# CITY OF ALBUQUERQUE

RE: **Navarette Residence**  
**10516 Olympic NW**  
**Grading Plan**  
**Engineer's Stamp Date 6/14/17 (File: A12D028)**

Based on the information provided in your submittal received 6/21/17, the Grading Plan cannot be approved for Building Permit until the following are addressed:

ENGINEER'S SEAL  7/20/17 DAVID SOULE P.E. #14522	NAVARETTE RESIDENCE 10516 OLYMPIC	DRAWN BY WCWJ DATE 7-20-17 21741-LAYOUT-5-29-17
	GRADING AND DRAINAGE PLAN	SHEET #
	 Rio Grande Engineering 1606 CENTRAL AVENUE SE SUITE 201 ALBUQUERQUE, NM 87106 (505) 872-0999	JOB # 21741

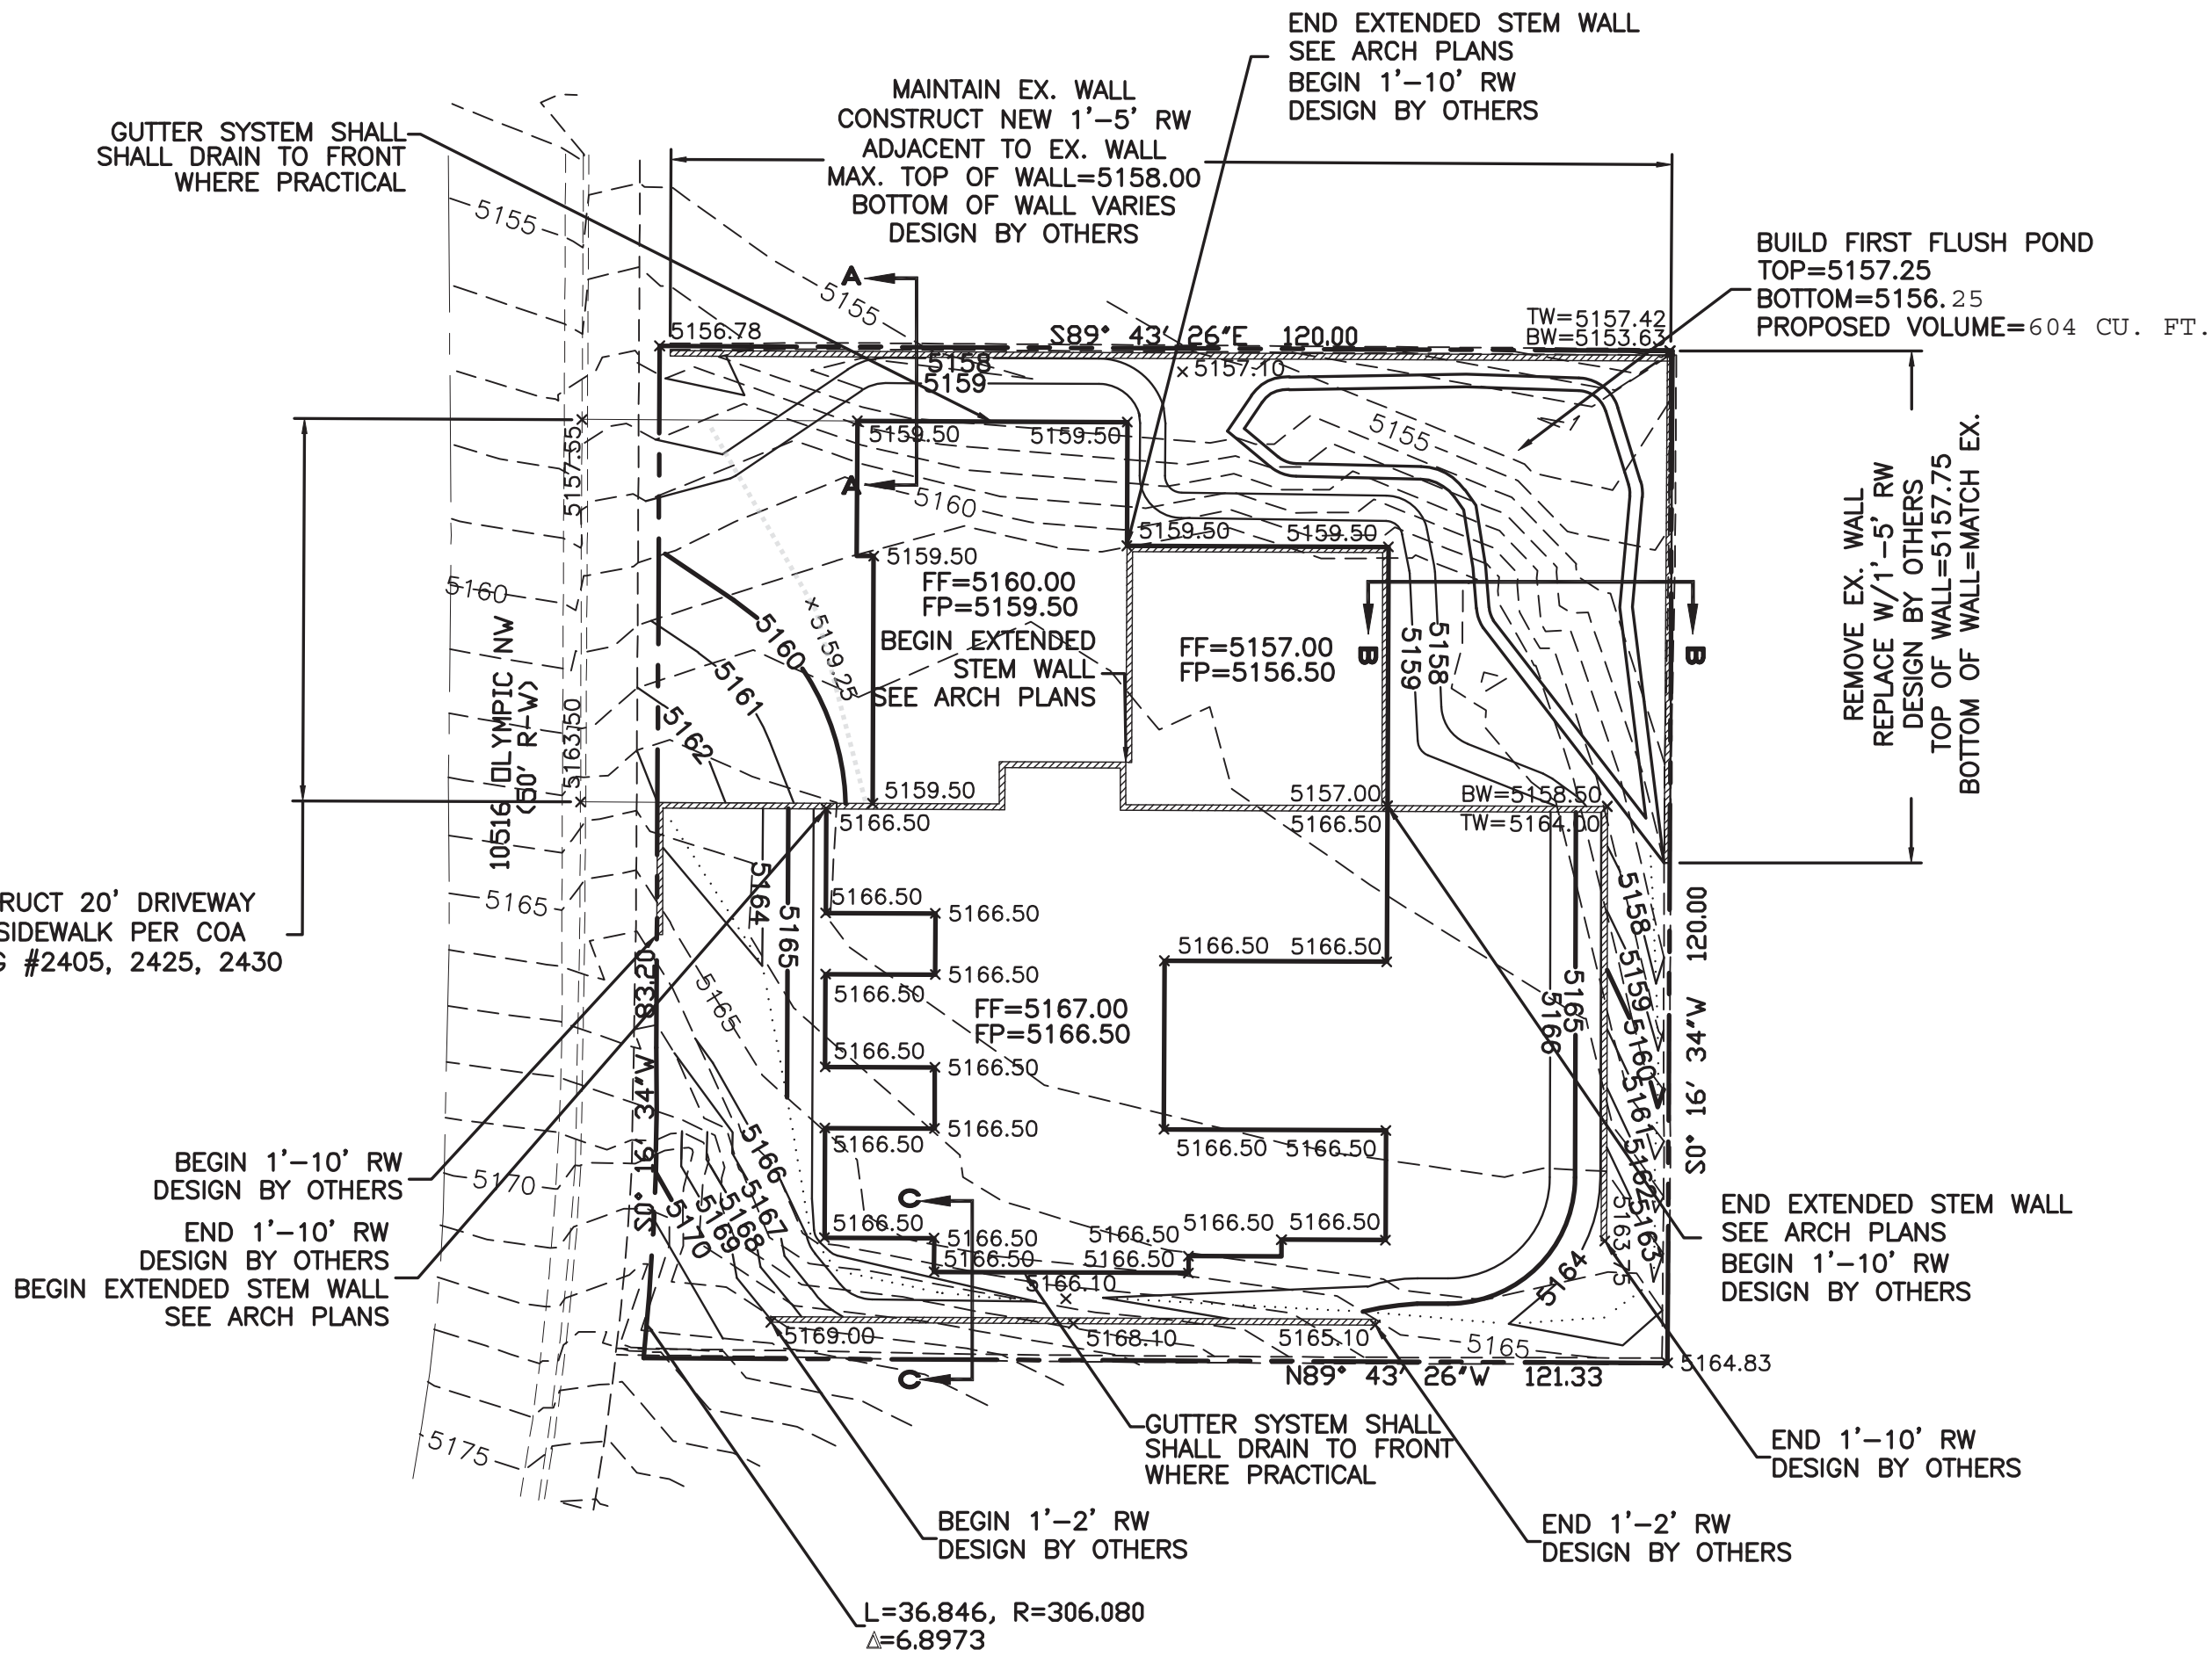
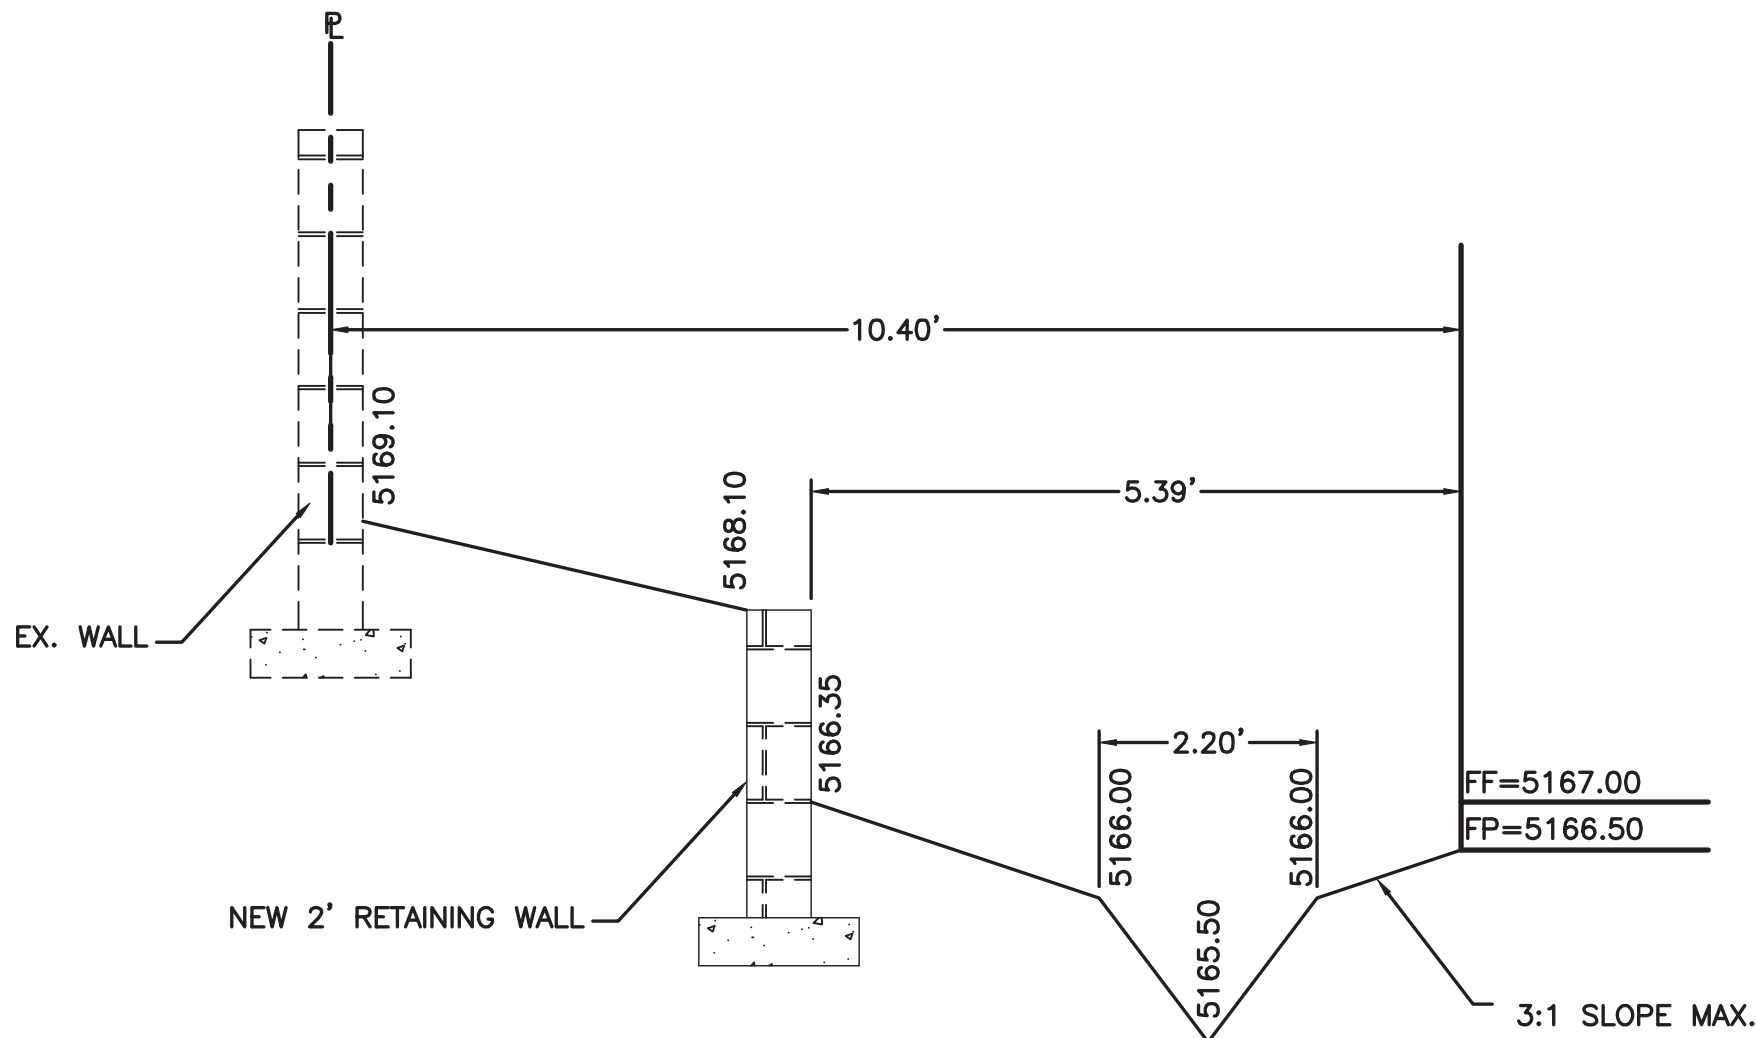
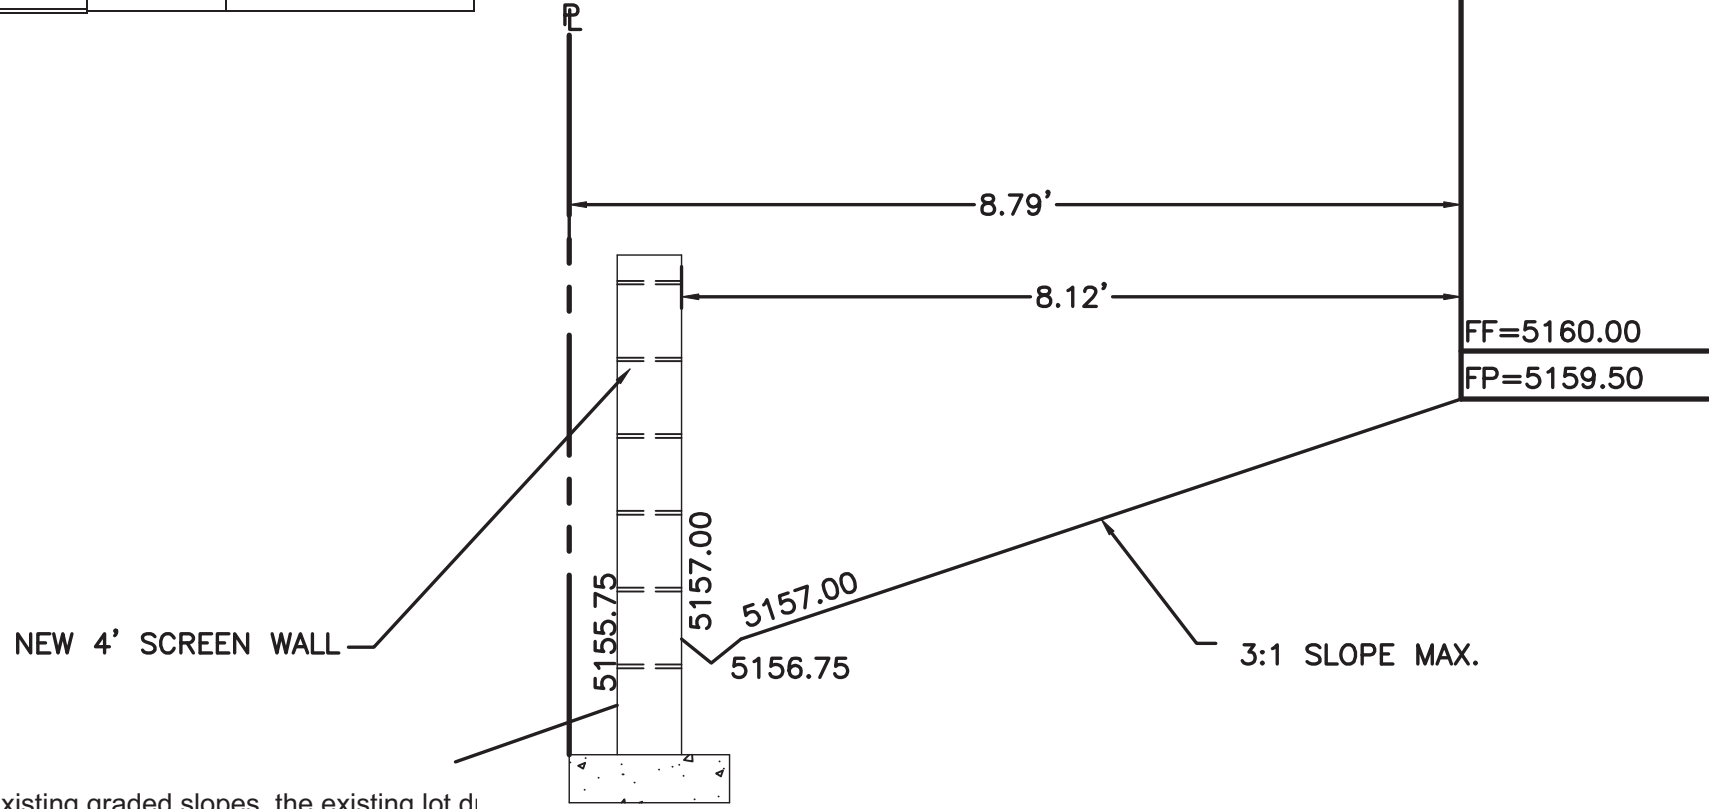
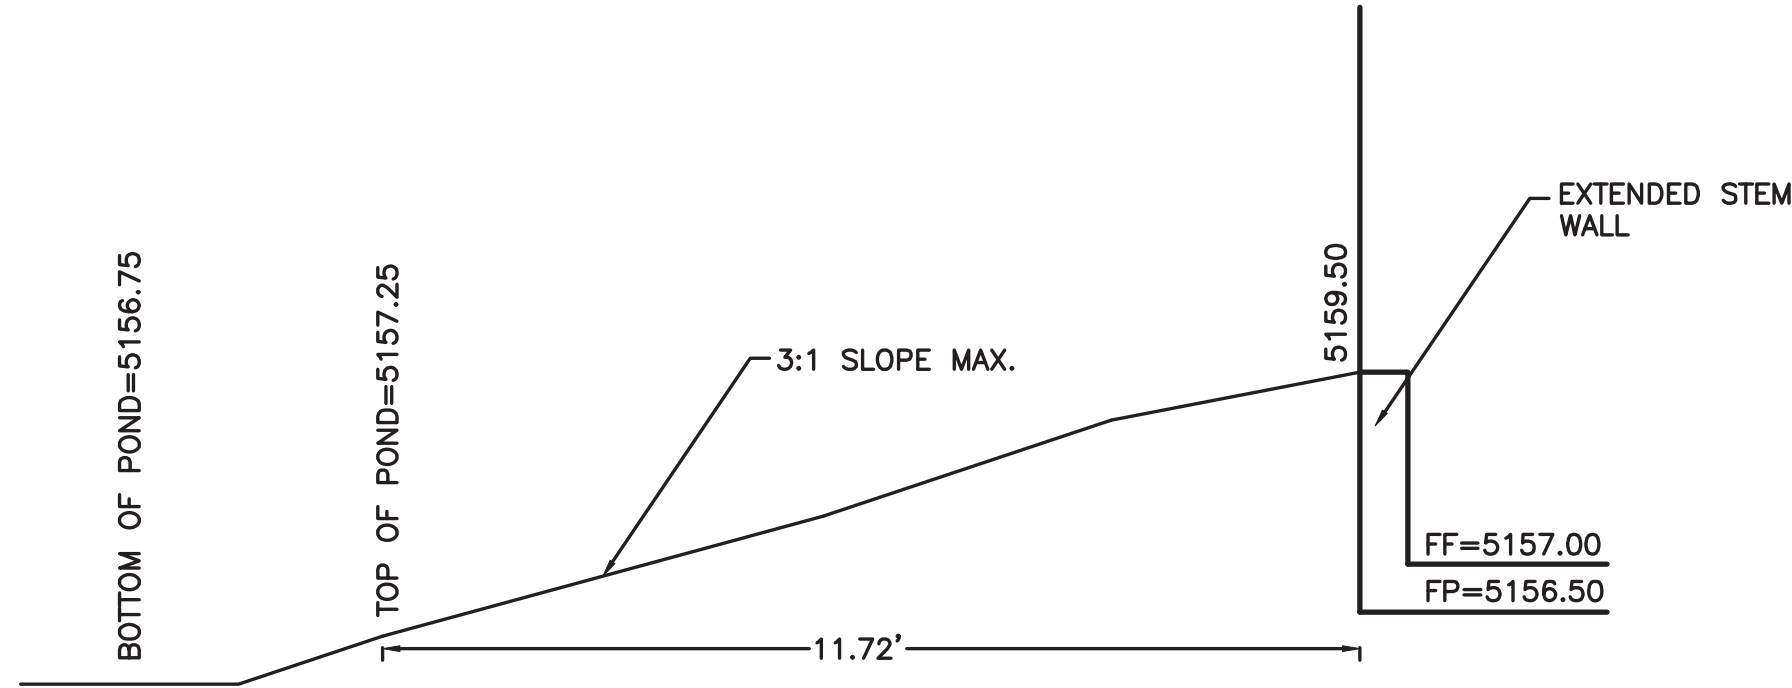
1. Section Views. Provide section cuts of several areas across this site:
  - a. The southwest corner, between the SW corner of the house, to the adjoining lot to the south.
  - b. In the back yard, through the two retaining to the property to the east.
  - c. The northwest corner, between the NW corner of the garage to the adjoining property to the north.
  - d. In the northeast corner, through the lowest floor at 5157.00 and the ponding area.

Ensure these section views show that the flowline is not set against any retaining walls or walls of the house and ensure below-grade finished floors have waterproofed retaining walls.

2. Contours. Extend the topographic data around all of the lot lines, not just on the west side of the lot. Also label contours for existing and increase label density of the proposed contours.
